City of Albuquerque
Stormwater Construction Site
Inspection Report

**Re: Floor and Decor
Erosion and Sediment Control Plan
Engineer's Stamp Date 1-26-18 (F17E032)**

**Re: Floor and Decor
Erosion and Sediment Control Plan
Engineer's Stamp Date 1-26-18 (F17E032)**

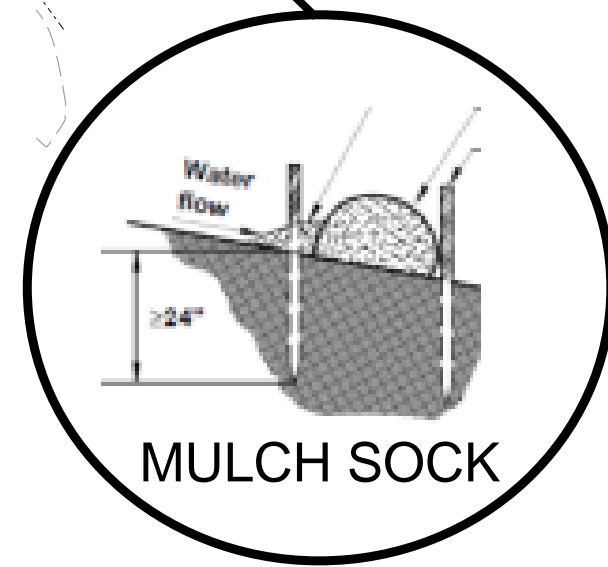
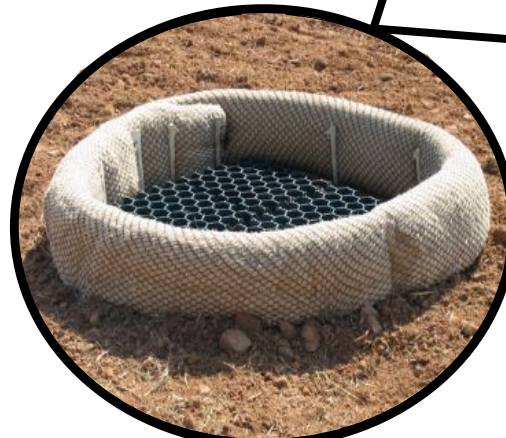
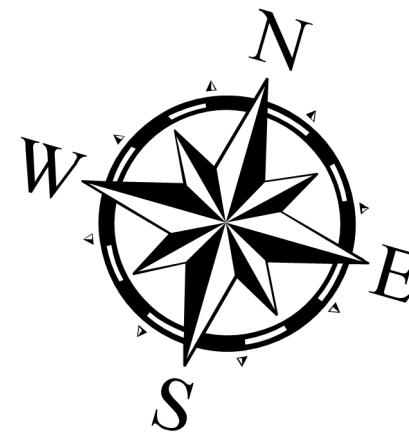
1. After discussion with the NMDOT, a sediment BMP should be proposed between the deceleration lane(s) and the swale on Pan American Frwy to prevent sediment from entering the swale area.

Good morning Curtis. That row of mulch sock isn't really doing anything. Can it be placed on the other side of the swale?

Tim,
The solid orange line is asphalt cut, I thought it was mulch sock at first, but I see what you mean a BMP on the east side of work area may help keep sediment out of the swale.
